From: [REDACTED]
Sent: 21 June 2017 09:25
To: Andrew Wood
Subject: Re: FG 198/16/PL - VERY URGENT

From: Andrew Wood
Sent: 21 June 2017 08:42
To: Juan Baeza
Subject: RE: FG 198/16/PL - VERY URGENT

BASEMENT FLOOR PLAN

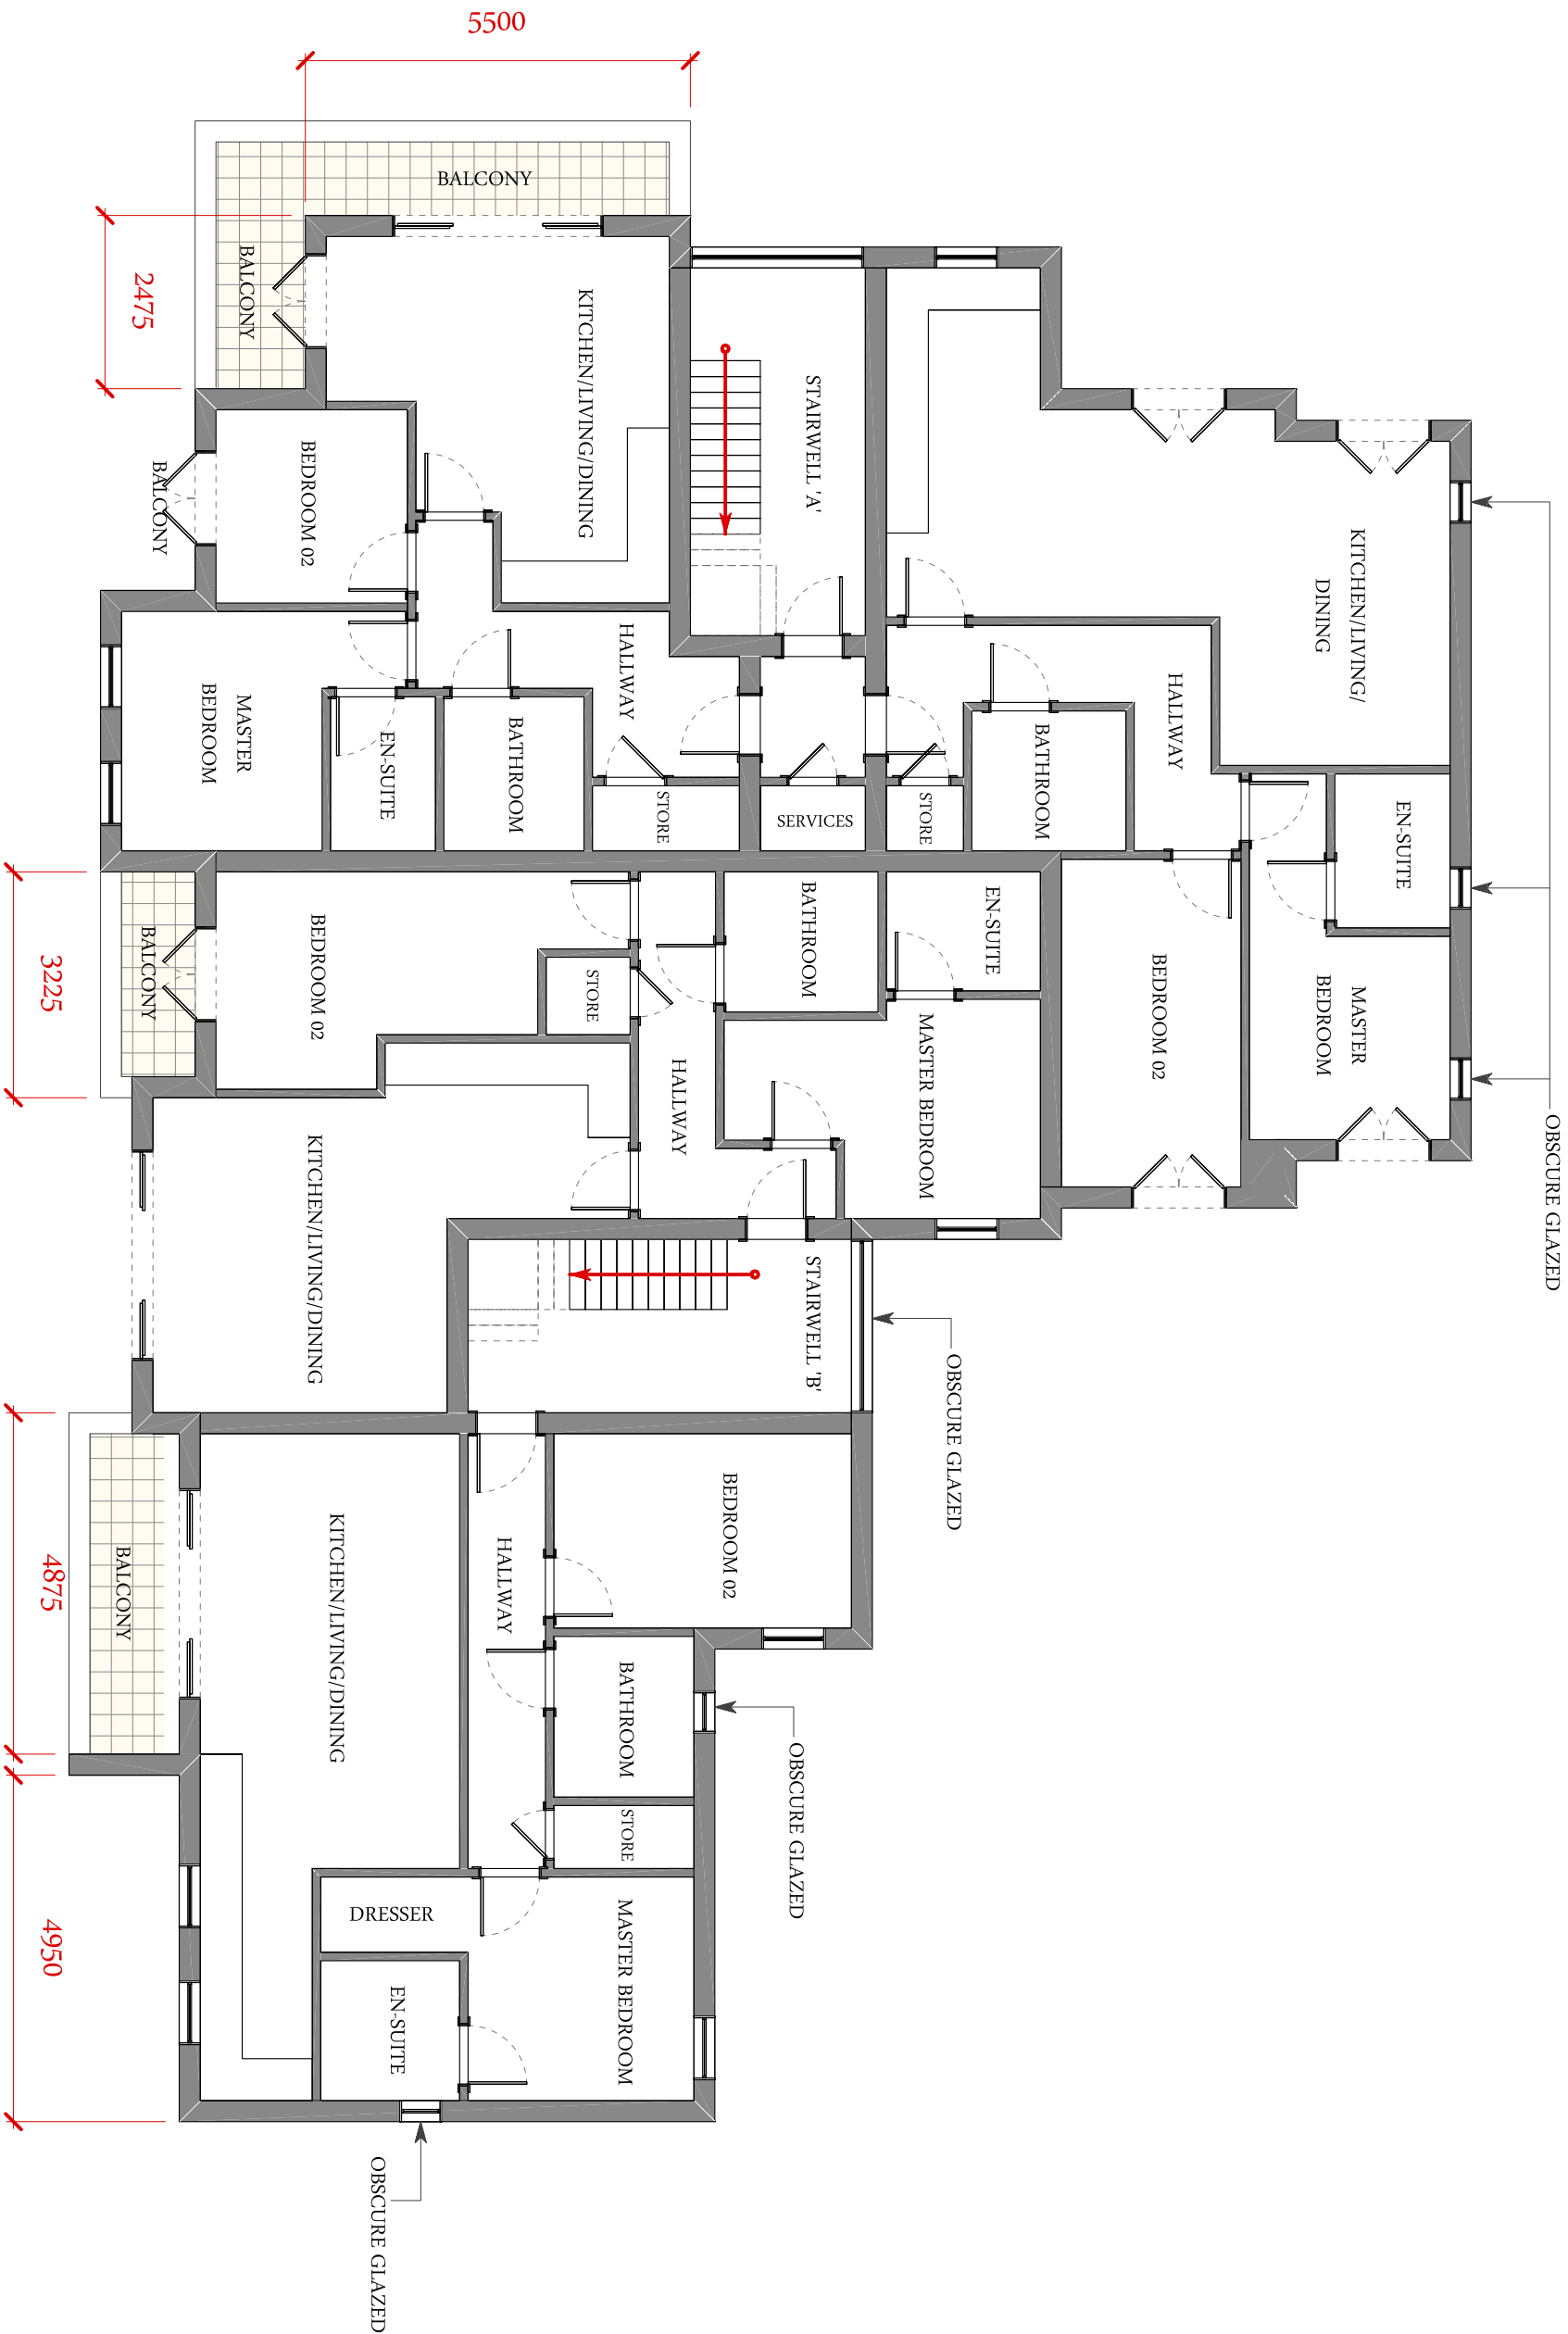
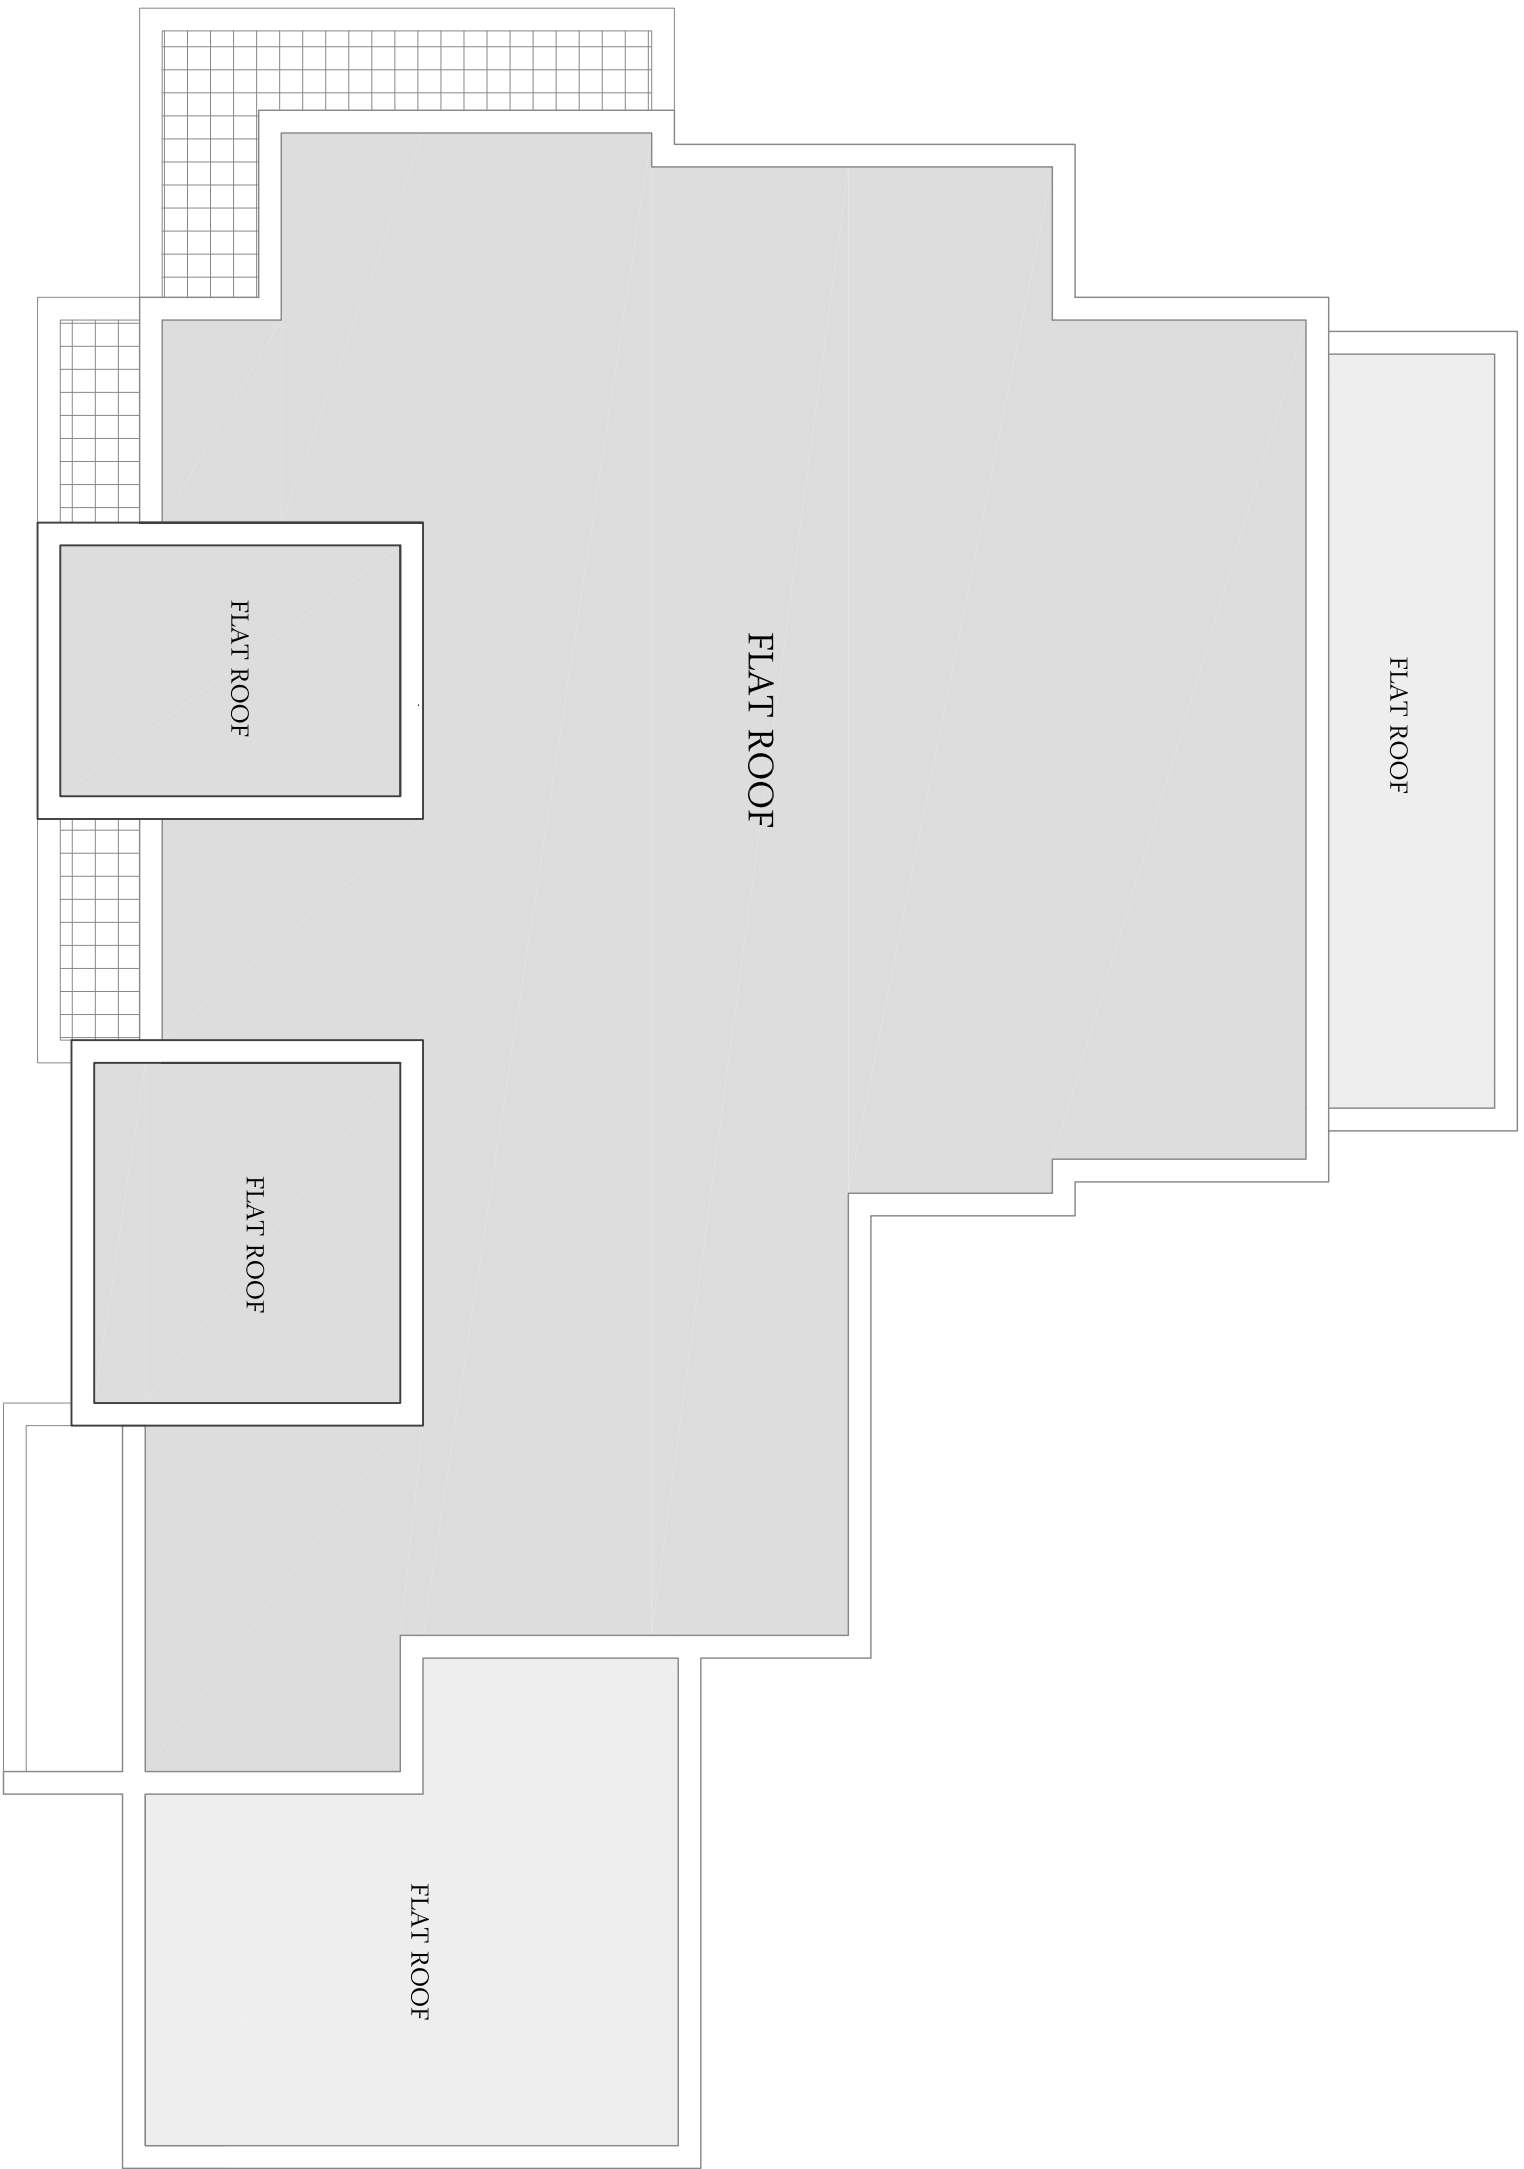
Since the ground floor windows were noted as obscure on the applicant's plans and because of the above combined with the raised ground floor height of the proposal, it is necessary to include them in the condition.

b.) Given that the report states that all windows on the West facing elevation will be obscure glazed bar the bedroom windows discussed above, why does proposed condition 14 only state that all first floor hallway, bathroom and en-suite windows at first floor level in the West and North elevations shall be obscure ? Why are the ground floor windows not included in this condition ? Why, also is the ground floor kitchen / living / dining window and the ground and first floor side windows to the master bedrooms not included in this condition ?

The Master bedroom window at first floor level was indicated to be obscure glazed on the plan PL004 Rev H however I have included it in condition 14 for the avoidance of doubt.

The ground floor windows would not overlook your property as shown in the attached photo. The sill height of windows at ground floor level would be 2.2 metres. Your garage wall along the boundary and the boundary hedge height are well in excess of this height. As a result it is not necessary to include the ground floor windows within the condition.
